Application by SEGRO Properties Limited for an order granting consent for the East Midlands Gateway Phase 2 (BC0410001) and East Midlands Rail Freight Interchange Material Change (TR0510002)

Deadline 5 submission

Leicestershire County Council Deadline 5 submission – 30.06.2026

HIGHWAY PLANS GENERAL ARRANGEMENT SHEET 2 OF 4

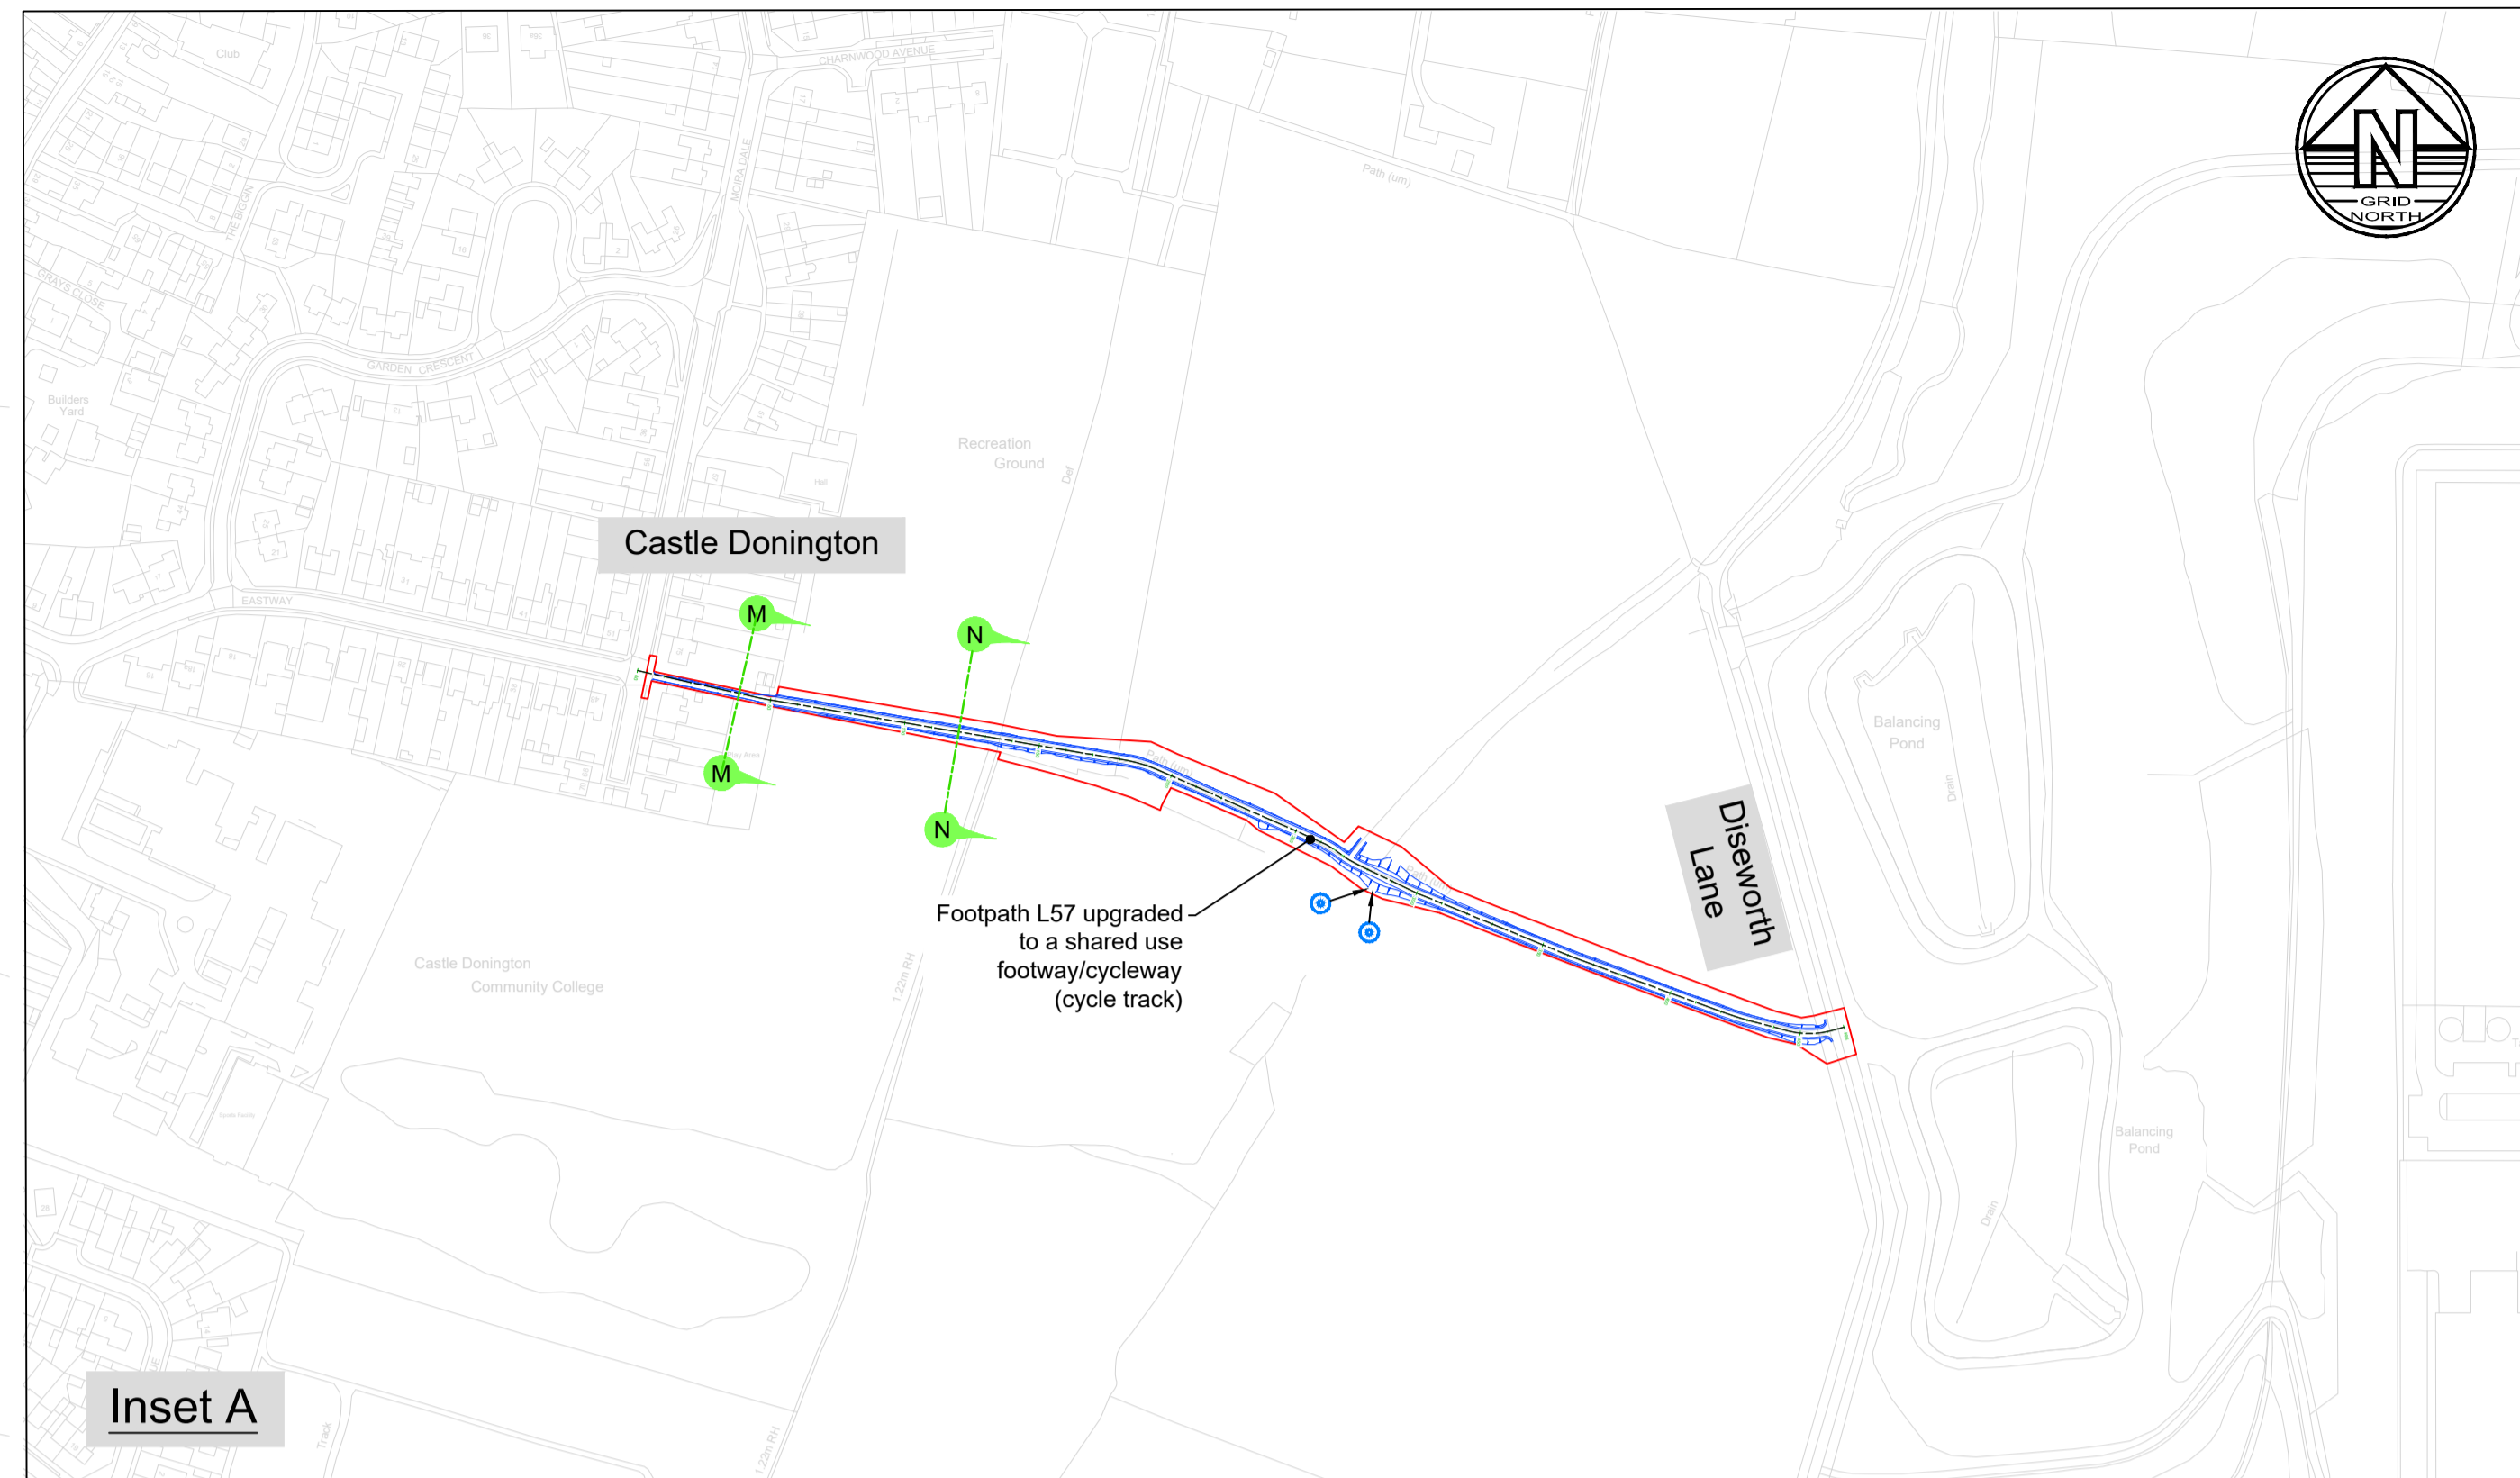
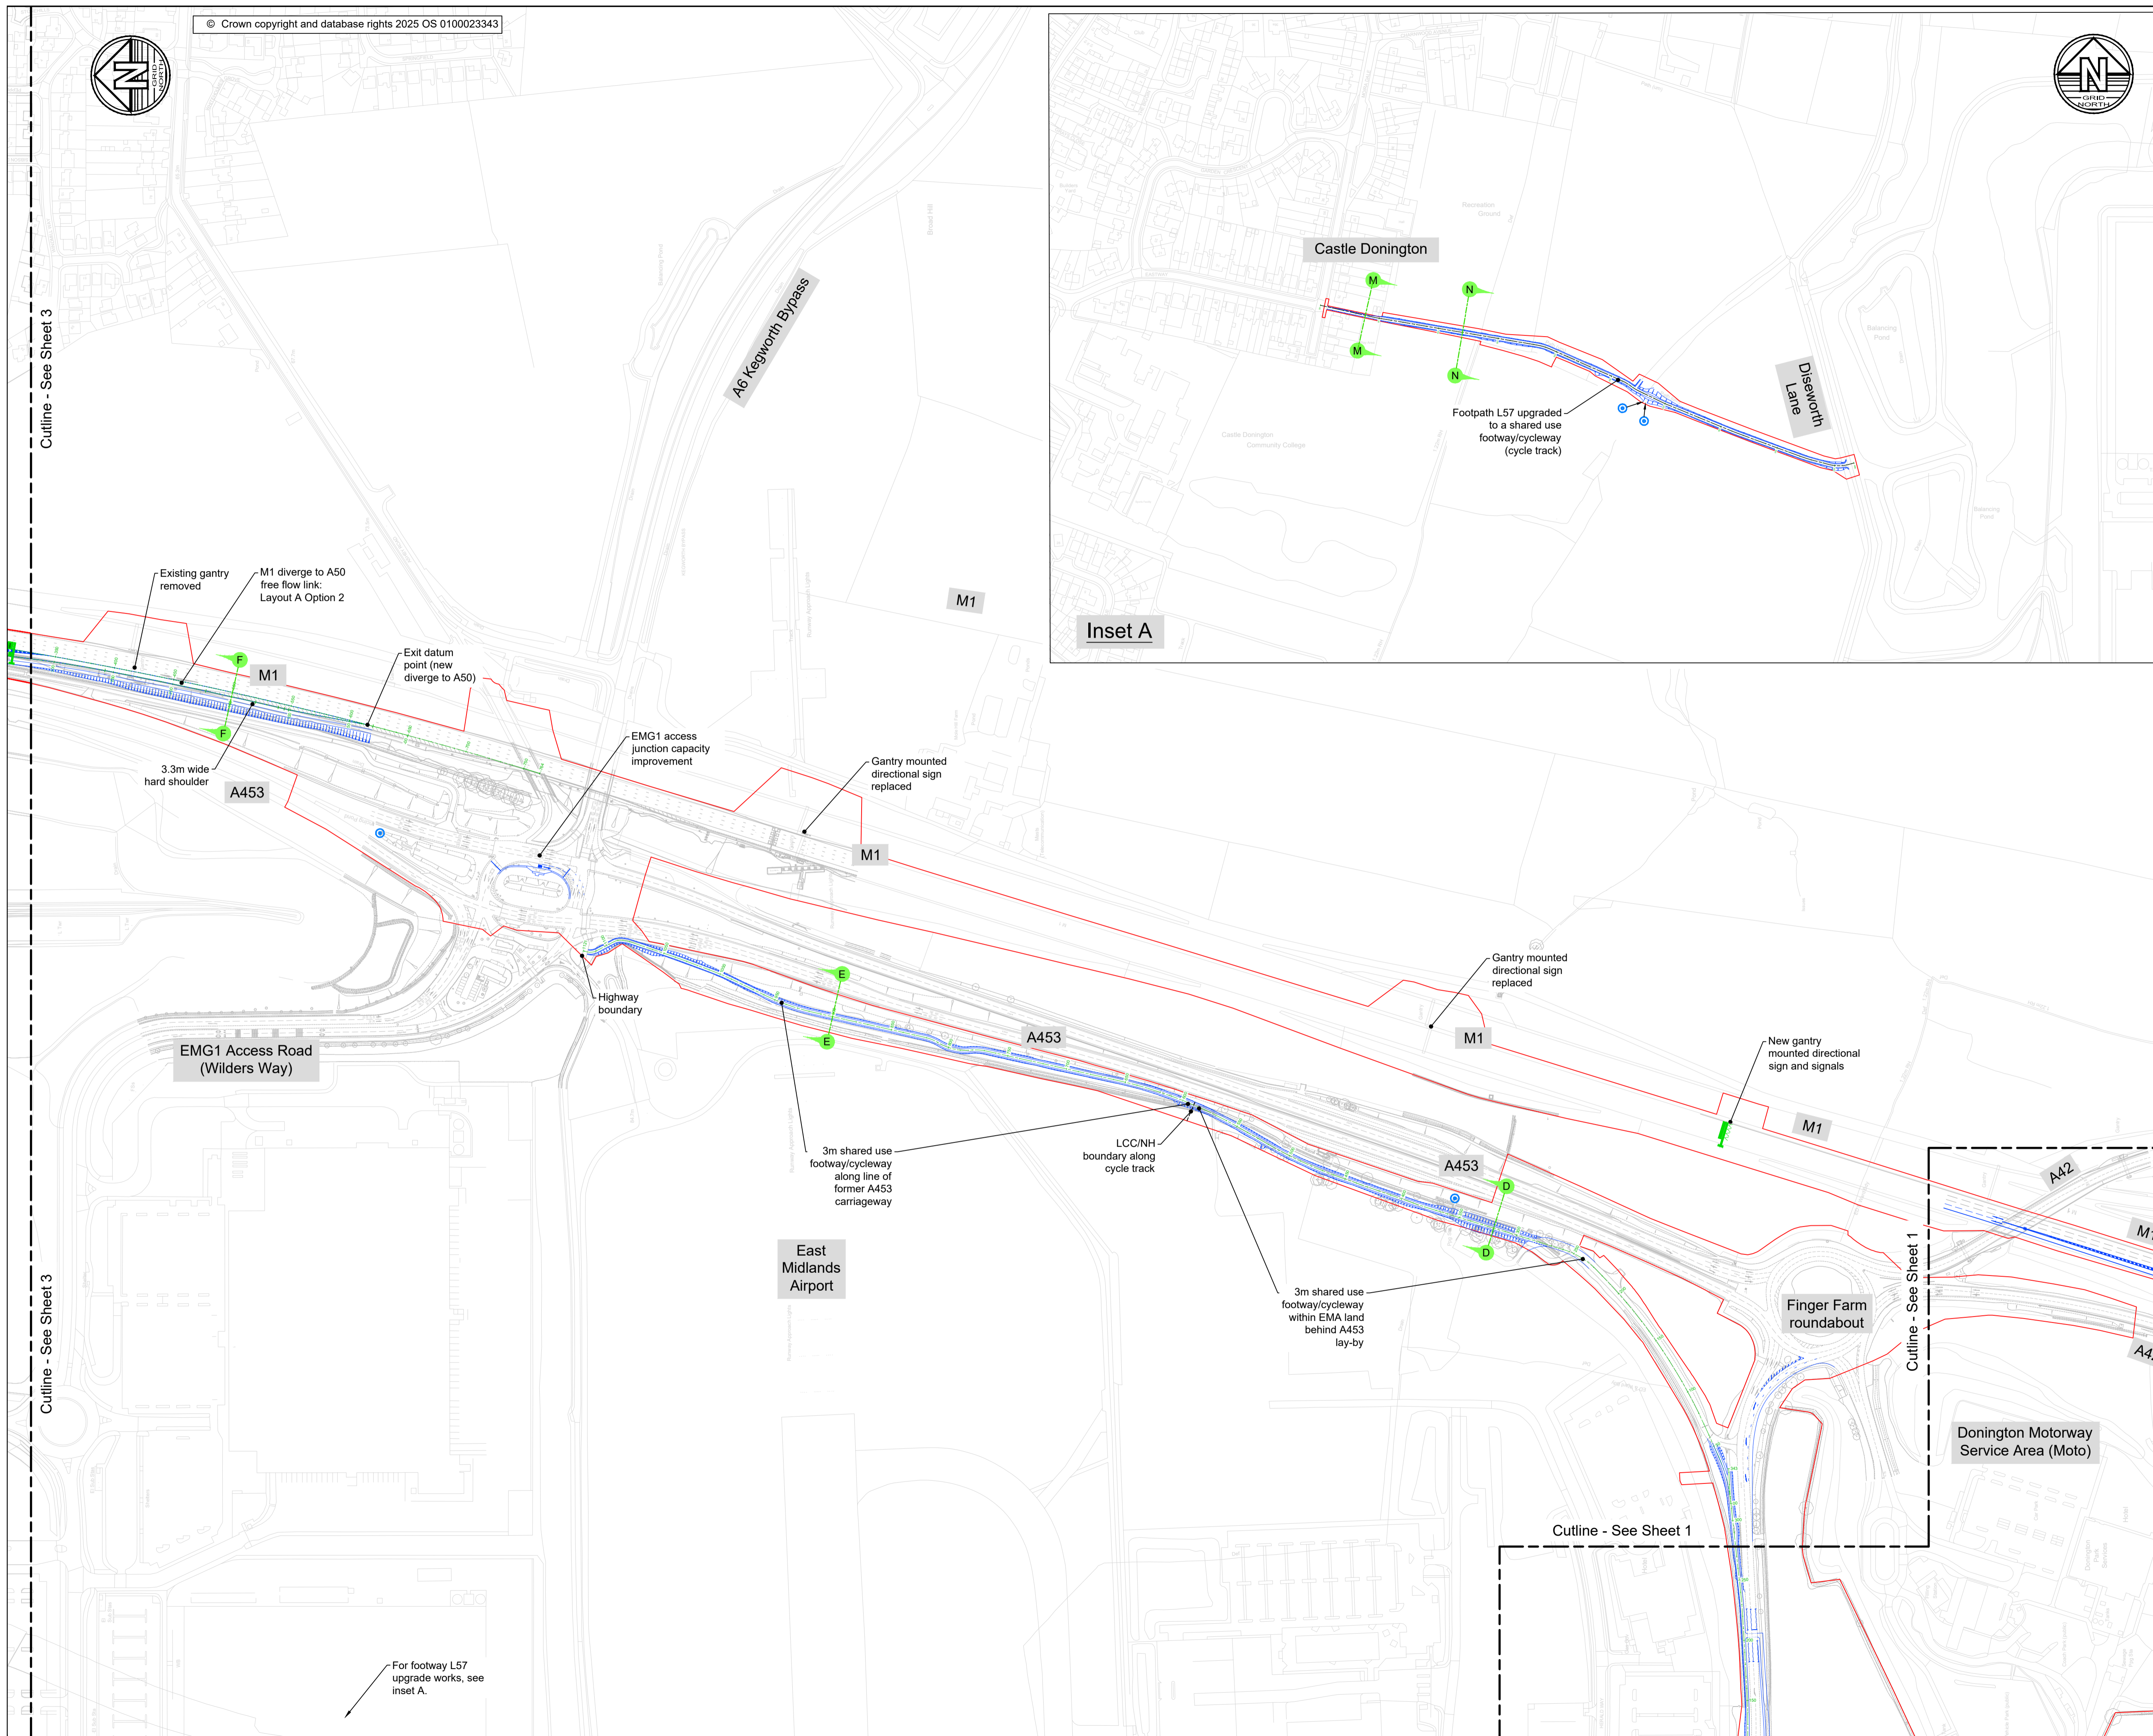
REP4-011D	Highway Plans General Arrangement Sheet 1	Amendment to reflect the introduction of a controlled pedestrian crossing on A453 – LCC welcome this amendment.
REP4-012D	Highway Plans General Arrangement Sheet 2	Amendment to reflect the revised alignment of the ATL - LCC have no comments to make on this amendment.
REP4-013D	Highway Plans Cross Sections Sheet 2	Amendment to reflect the revised alignment of the ATL - LCC have no comments to make on this amendment.
REP4-014D	Highway Plans Long Sections Sheet 3	Amendment to reflect the revised alignment of the ATL - LCC have no comments to make on this amendment.
REP4-015D	Community Park Plan	Additional footpath added - see response to ExQ2 1.2.1 for further details – LCC have no comments to make on this amendment.
REP4-019	Appendix 3A of the ES - CEMP	Updated Construction Traffic Management Plan to address comments made by Leicestershire County Council at ISH3– LCC note an error in this revised document. Incorrect reference is made to the Pan Regional Transport Model being a Paramics model. This is not the case. LCC remains concerned with the associated proposed disapplication of section 141 of the Highways Act 1980 as set out in Schedule 14 of the dDCO and as documented in LCC’s submissions at deadline 1 [REP1-087] and deadline 4 [REP4-060D].
